From: Planning
Subject: FW: App 3/2024/1000 Barn at Greengore Hill Lane Hurst Green - Ecology Response

Re App 3/2024/1000 Barn at Greengore Hill Lane Hurst Green - Change of use of land to form extended residential curtilage and construction of residential storage building. Formation of new vehicular access from Hill Lane for new agricultural building.

Drawing Title
 Proposed Site Plan

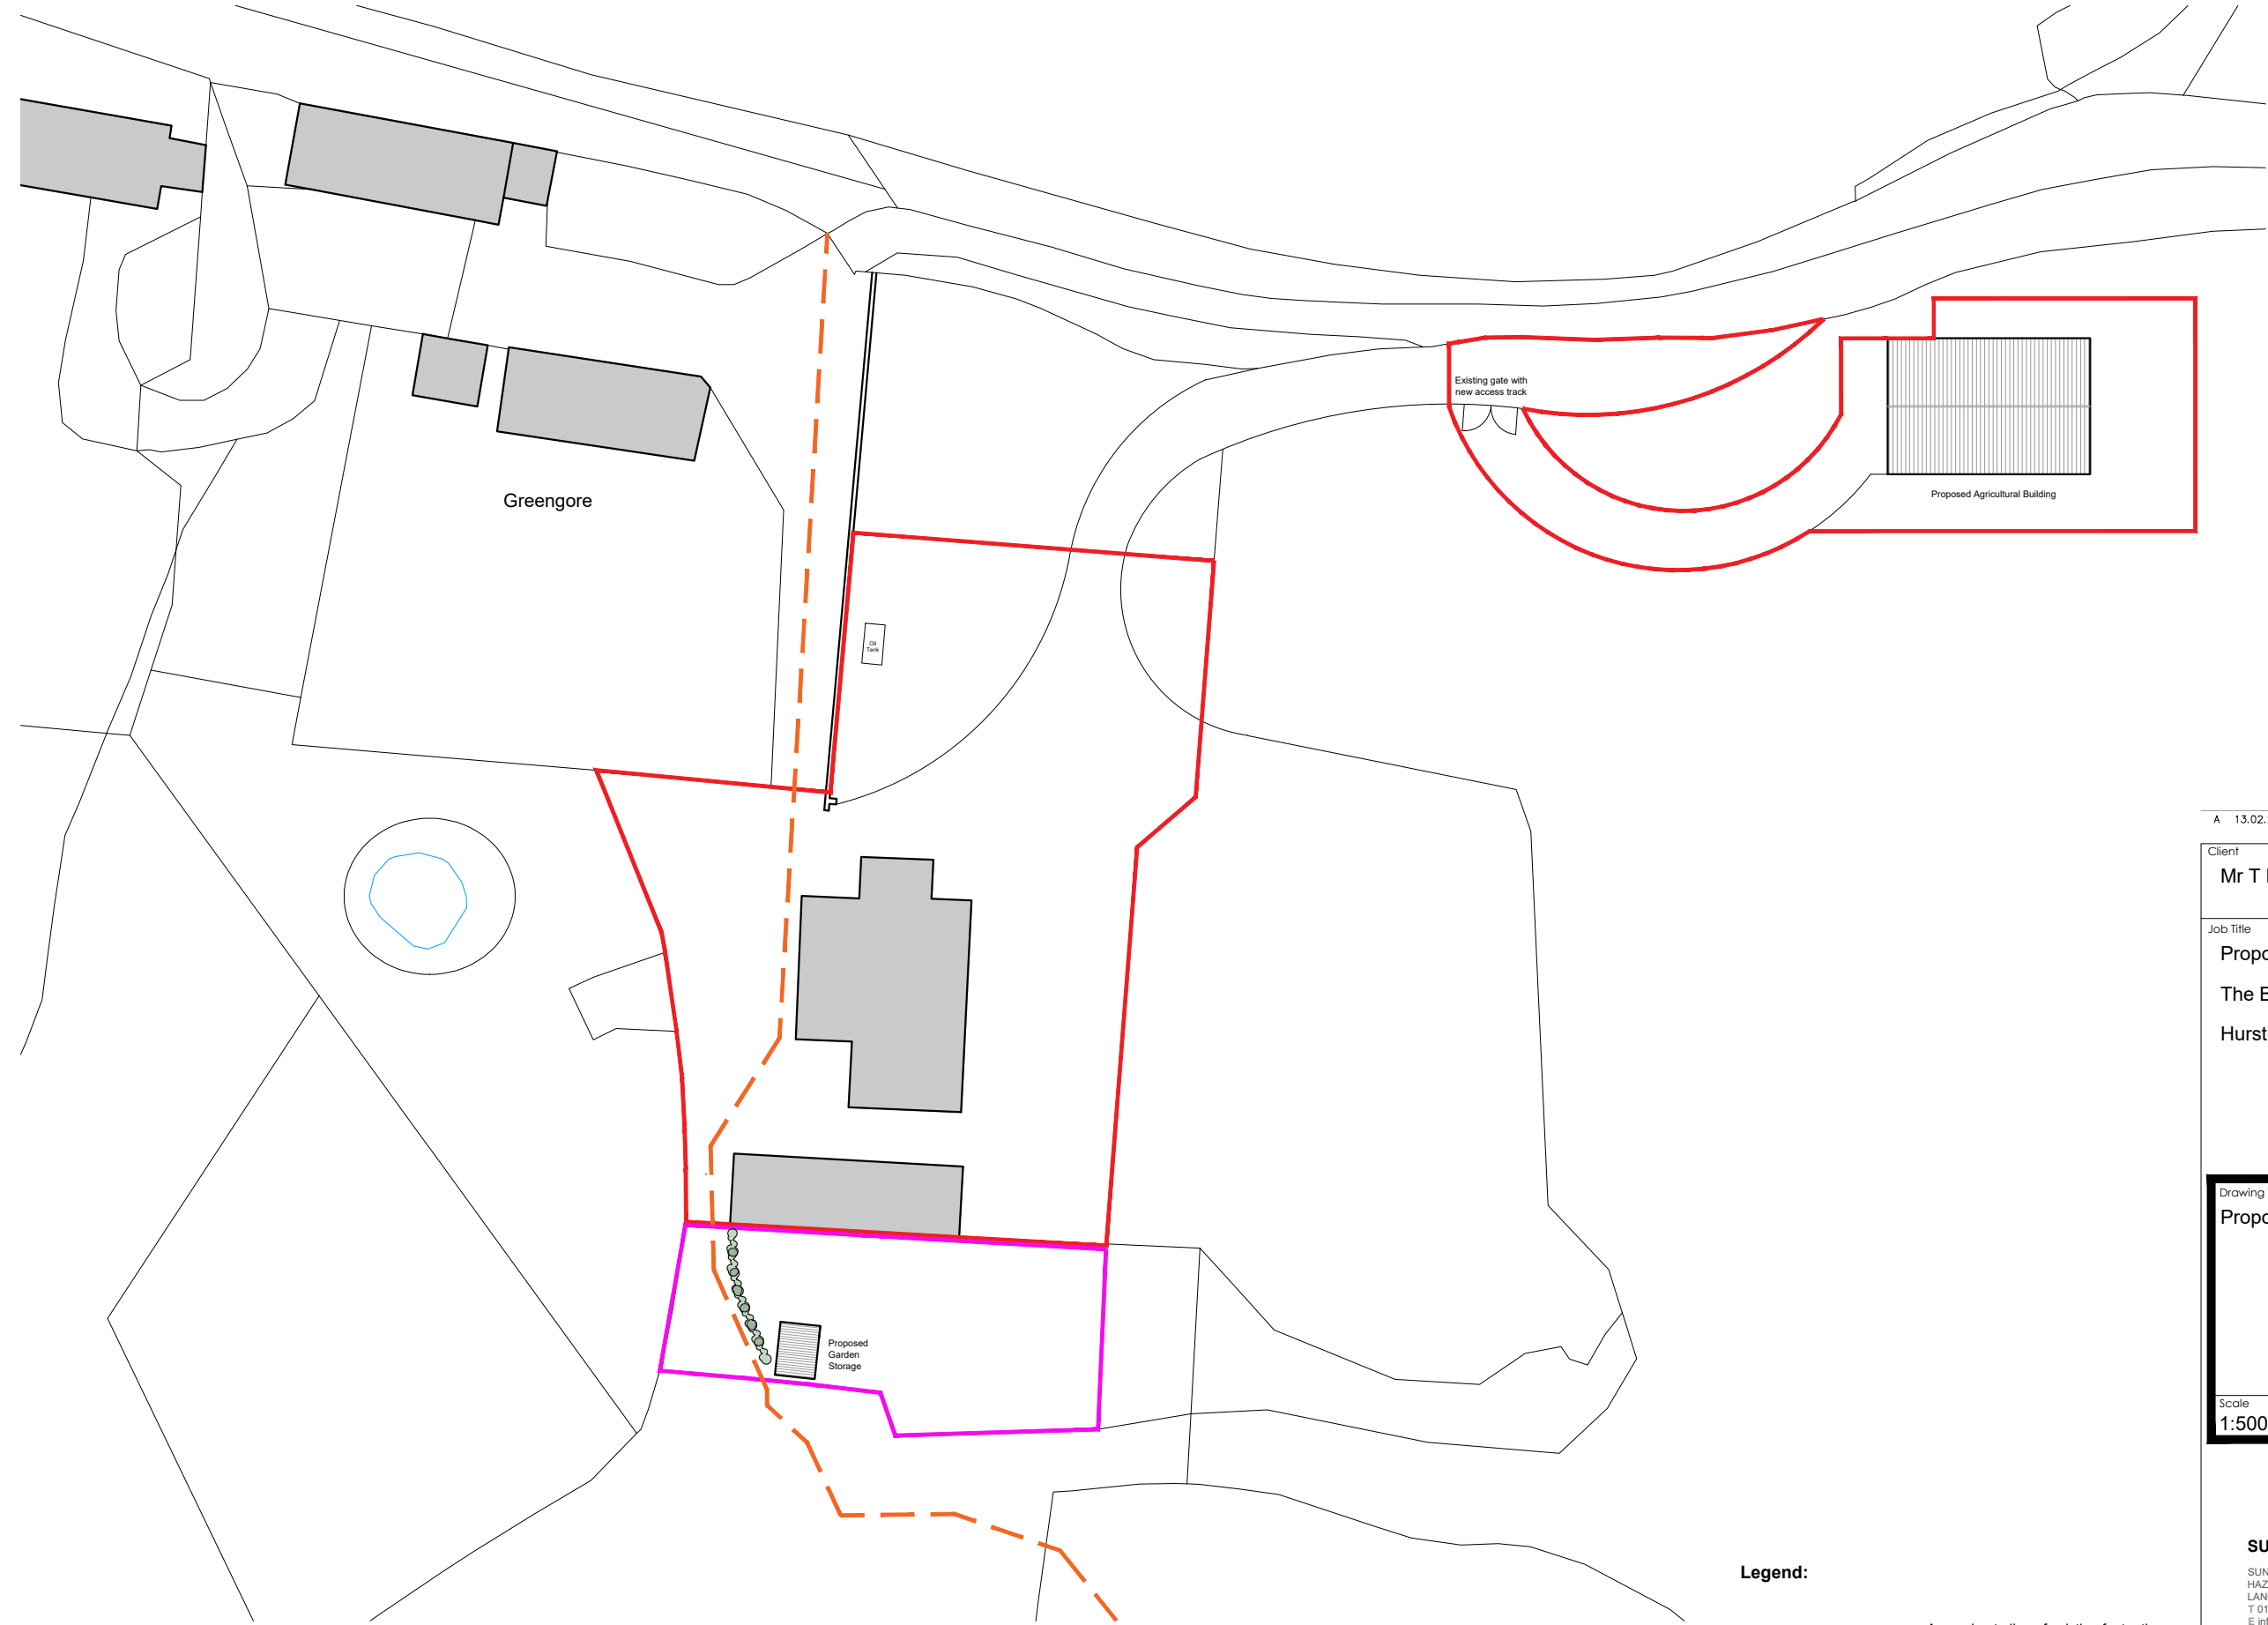
The BNG Report provided with the above planning application appears to have only included the area of land proposed to accommodate the agricultural storage building, and has not assessed the area proposed to form the extended residential curtilage. I would advise that the BNG Report is revised to provide a more accurate baseline habitat assessment. The inclusion of the proposed new garden space may increase the habitat creation required to achieve at least a 10% gain in biodiversity.

In this location, the installation of new bird nesting and bat roosting boxes on the new building(s) would be a useful biodiversity enhancement.
